Rezoning Transportation Analysis

Petition Number: #2022-024

3Revision Log:

SHEET NUMBER  
**RZ-01**

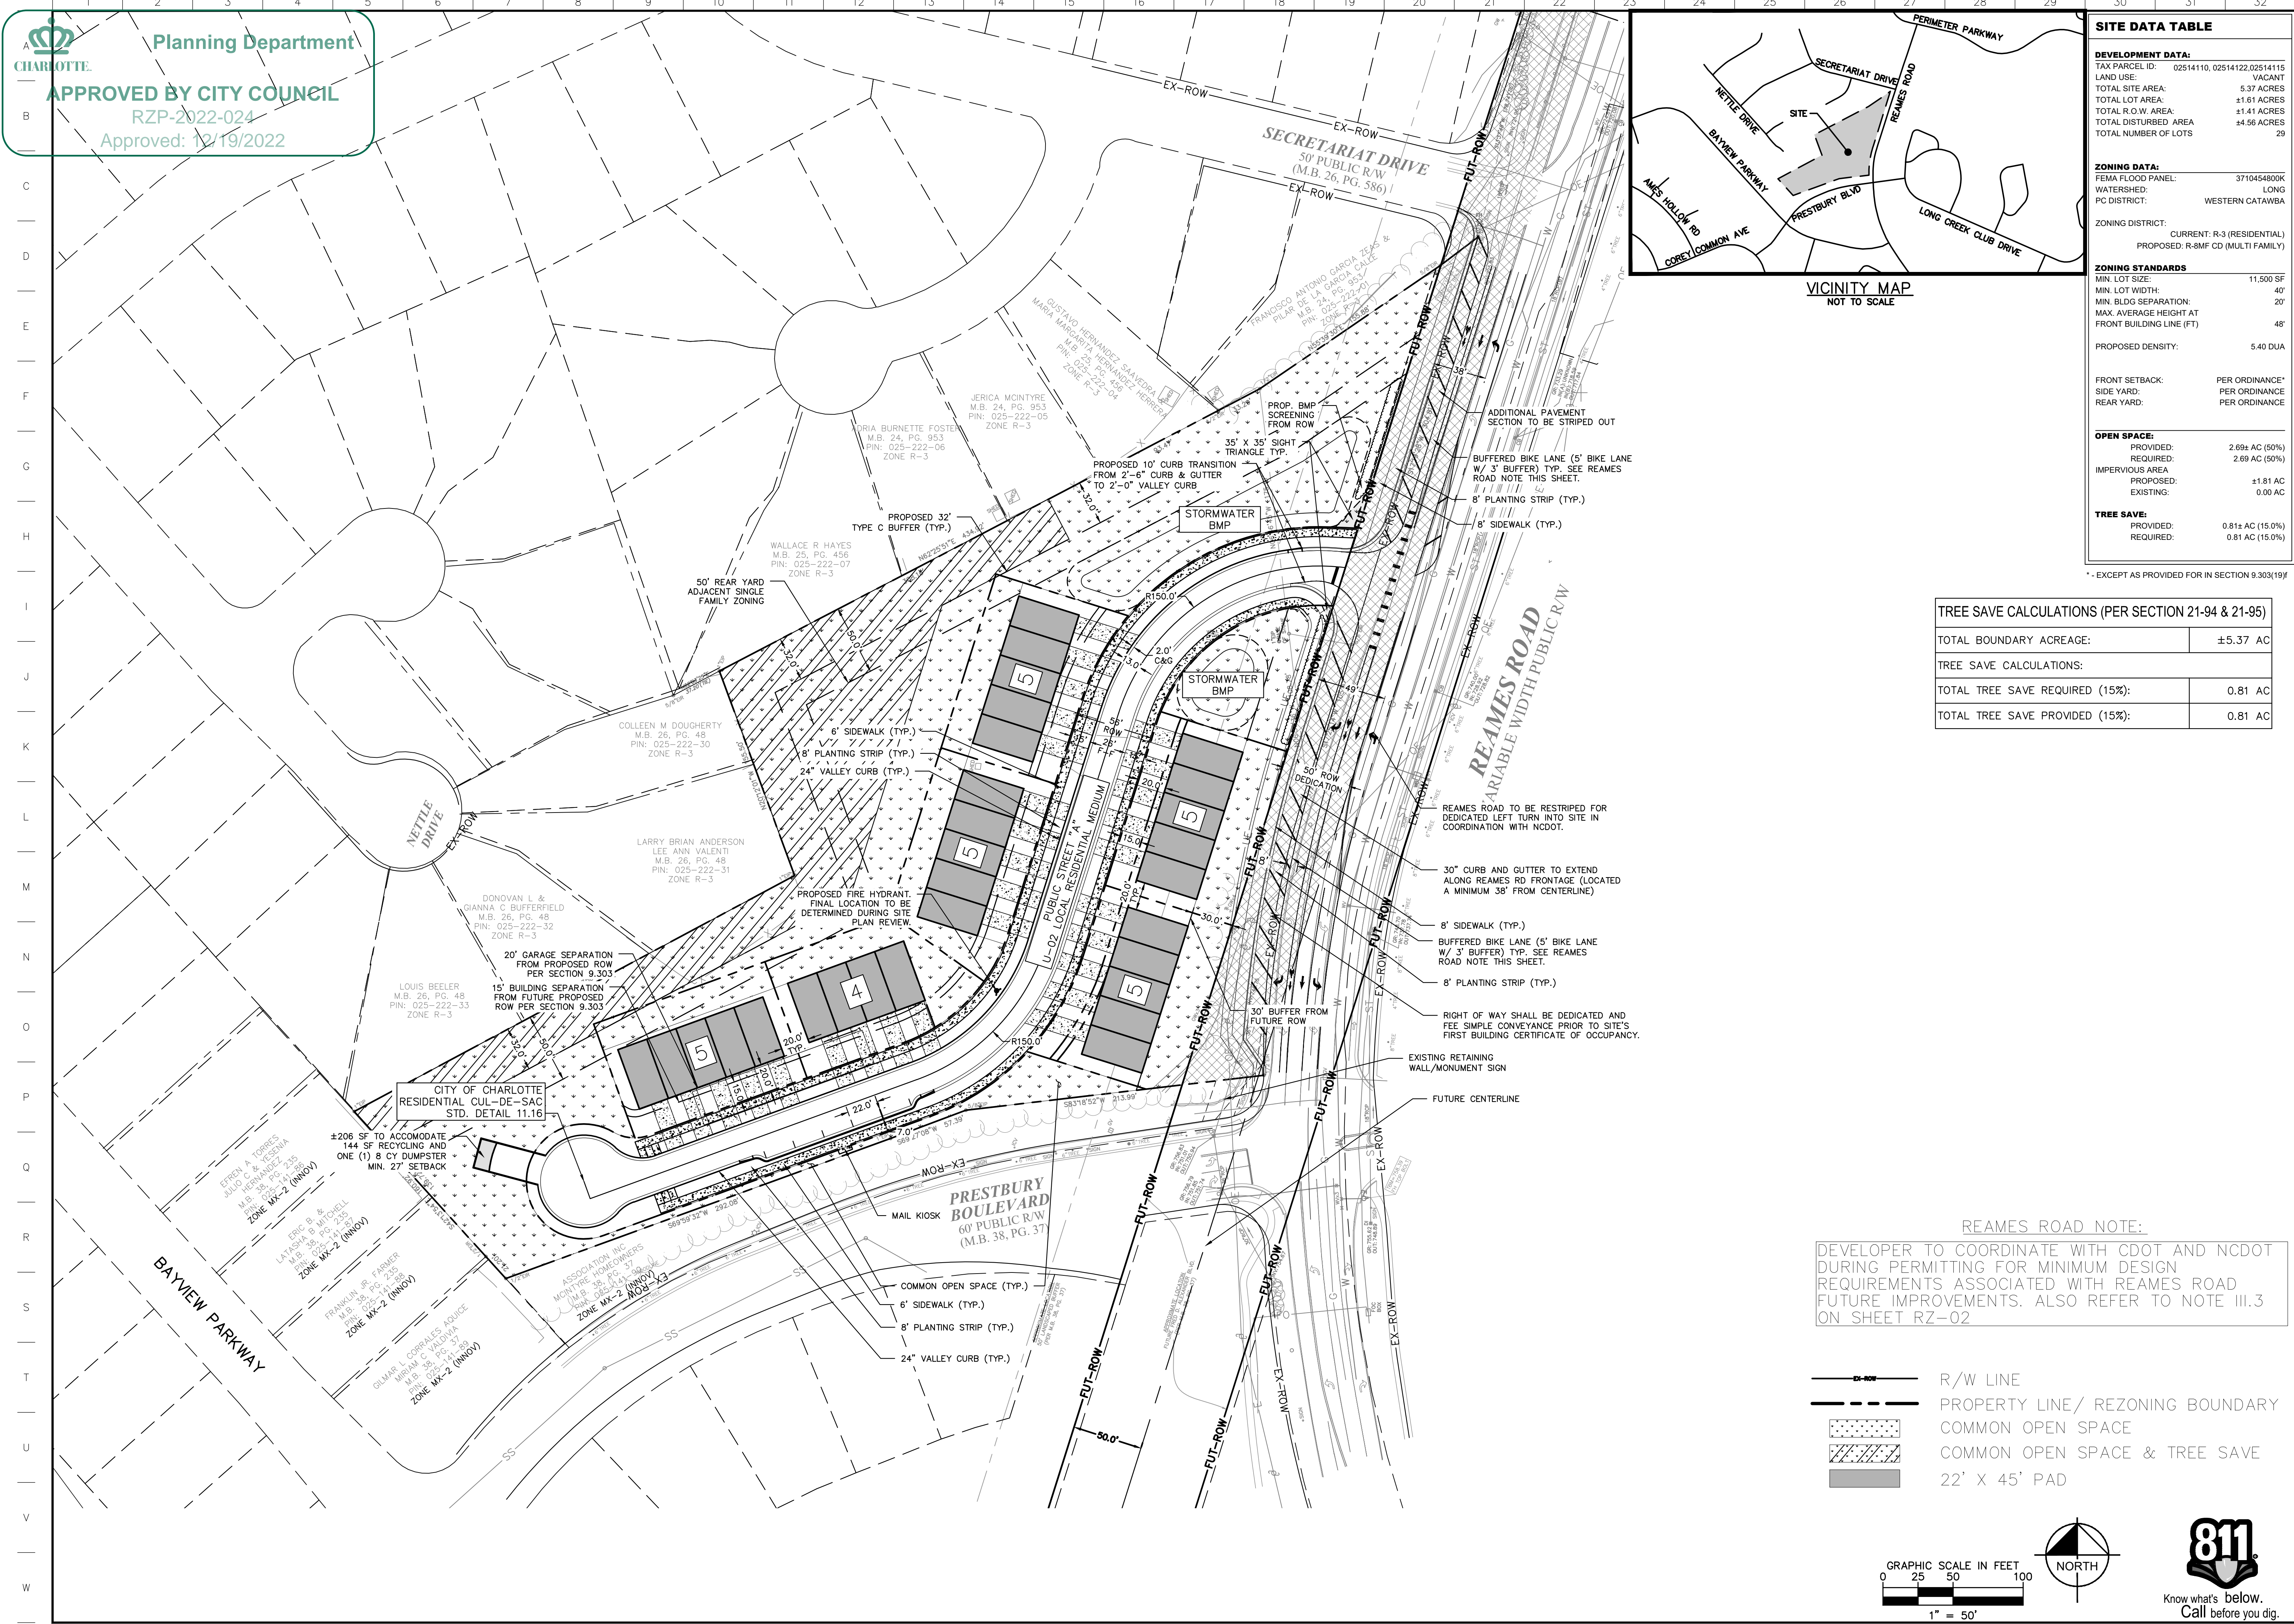
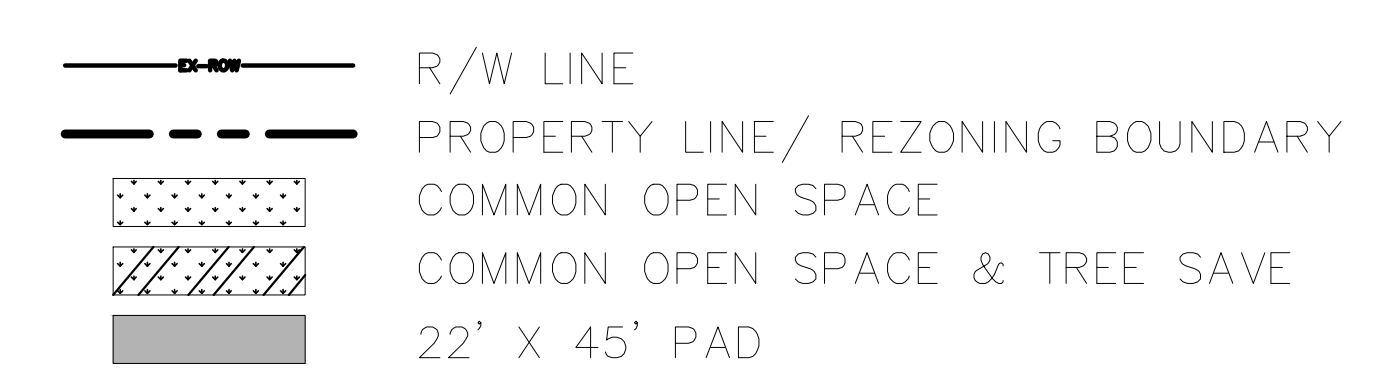
1. **Curbline:** The proposed zoning district has a setback measured from back of the existing or proposed future curbline.
 - a. **Reames Road:** The future location of curb and gutter is located 38-feet from the centerline.

Outstanding Comment from 07-26-22: Label and dimension the curb and gutter from the centerline for each road on the site plan.
2. ~~**Traffic Study:**~~
~~A Traffic Impact Study (TIS) is not necessary for the complete review of this petition due to the site generating less than 2,500 daily trips. If during the permitting process the site generates more than 2,500 daily trips, then a traffic study will be required.~~

3. **Outstanding Comment from 07-26-22:** Revise site plan and conditional note(s) to commit to dedicate 50-feet of right-of-way from the road centerline. The site plan shall label and dimension the right-of-way from the Reams Road centerline.

4. **Outstanding Comment from 07-26-22:** Site plan and conditional note(s) revisions are needed to commit to restriping Reames road for a left-turn lane into the site per NCDOT coordination. Label and dimension left-turn lane on site plan and add conditional note describing all turn lane design requirements.

5. **Outstanding Comment from 07-26-22:** Site plan revisions are needed to dimension to location of the future right-of-way to be dedicated for the proposed CTP alignment.

6. **CDOT REQUEST:** CDOT requests the internal street be constructed as a private street built to public street standards.
7. **Outstanding Comment from 07-26-22:** Site plan and conditional note(s) revisions are needed to commit to construct bicycle facilities by locating the curb and gutter 38' from the center line to meet the Charlotte BIKES Council-Adopted Policy. The right turn lane for Prestbury Road is not accounted for in the 38-foot measurement, so additional space will be required for the existing right turn lane. Provide buffered bike lane along the frontage of the site between the through and right turn lane.
